KITTITAS COUNTY

DEPARTMENT OF PUBLIC WORKS

TO: All Staff
FROM: Public Works Plan Review Team
DATE: September 14, 2022
SUBJECT: LPF-22-00006 Forest Ridge Ph. 4

| CHKD BY D.L.P. | SCALE 1" = 500' | SHEET 3 OF 13 |

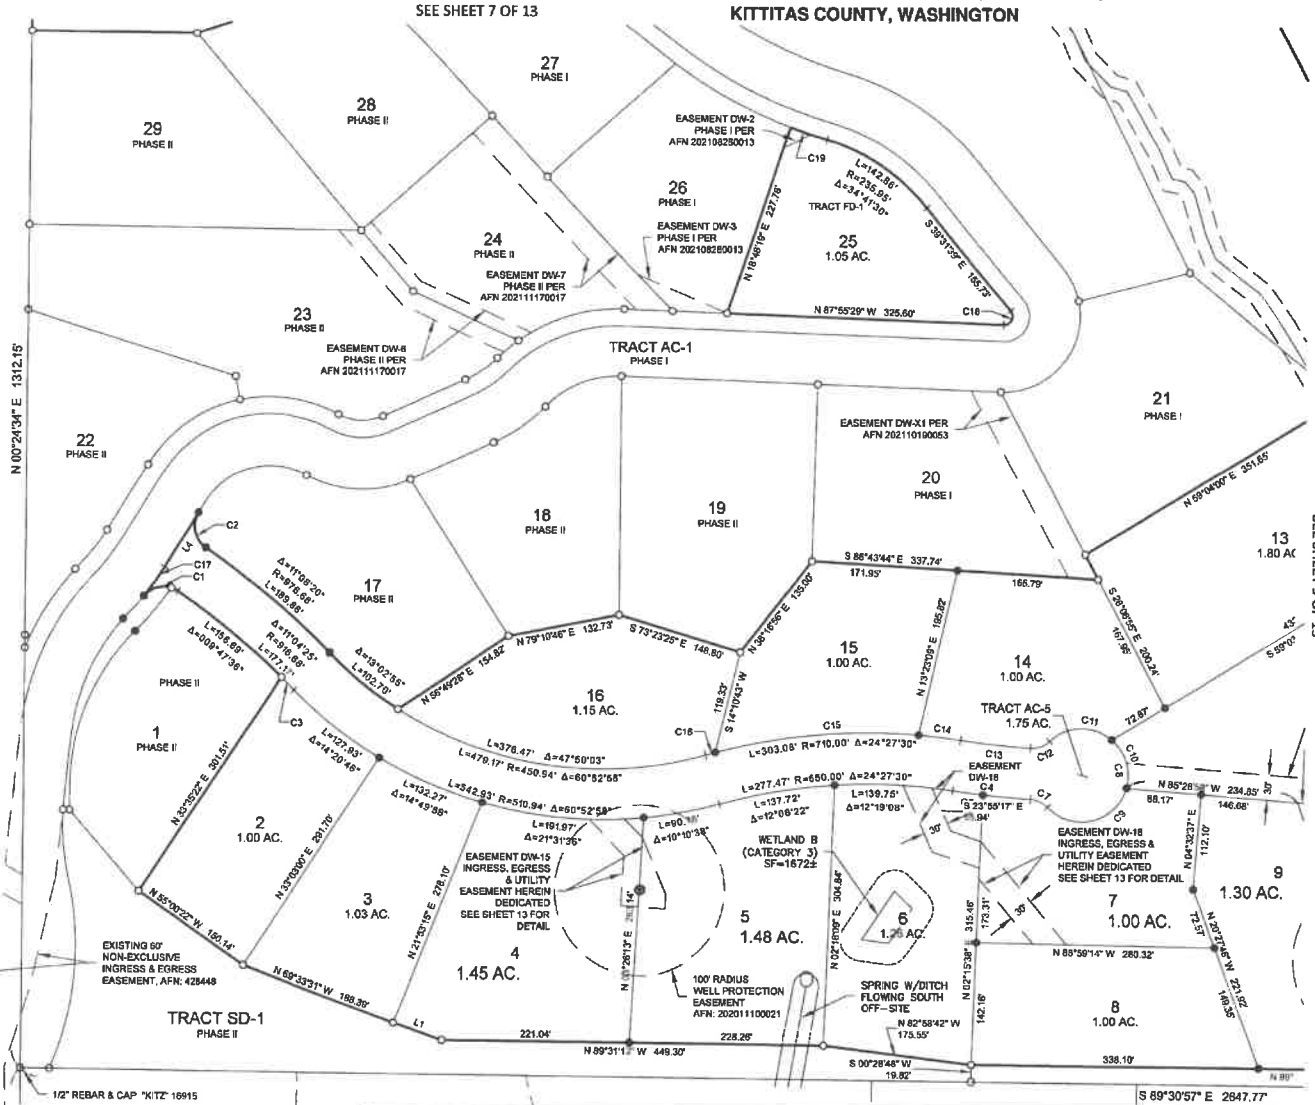
SURVEY	<p>Sheet 3</p> <p>1. Multiple occurrences of dimensions being obscured by crossing linework.</p> <p>Sheet 4</p> <p>2. Lots 2-16 and Lot 25 are not tied to Section line data.</p> <p>3. Lots 4, 6 and 7 have dimensions obscured by crossing linework or text.</p> <p>4. The south boundary of Lot 8 and SE boundary of Lot 7 are missing the bearings.</p> <p>Sheet 5</p> <p>5. Lots 7, 8, 13 and 66 have text cut off by the viewport.</p> <p>Sheet 6</p> <p>6. Lot 66 and 75 has text cut off by viewport.</p> <p>7. The 30' width arrows for Ease DW-19 appear to be part of the dimension arrow for a curve on Lot 74. This is confusing.</p> <p>Sheet 8</p> <p>8. Line Tags at North lines of Lot 81 are cut off by the viewport.</p> <p>9. AC-6 should be labelled.</p>
FLOOD	No comment
WATER MITIGATION/METERING	<p>Requirements for final plat approval have not been met.</p> <p>Prior to final plat approval the applicant must provide a copy of the approved Showing of Compliance with 90.44.100(3) from Ecology.</p>
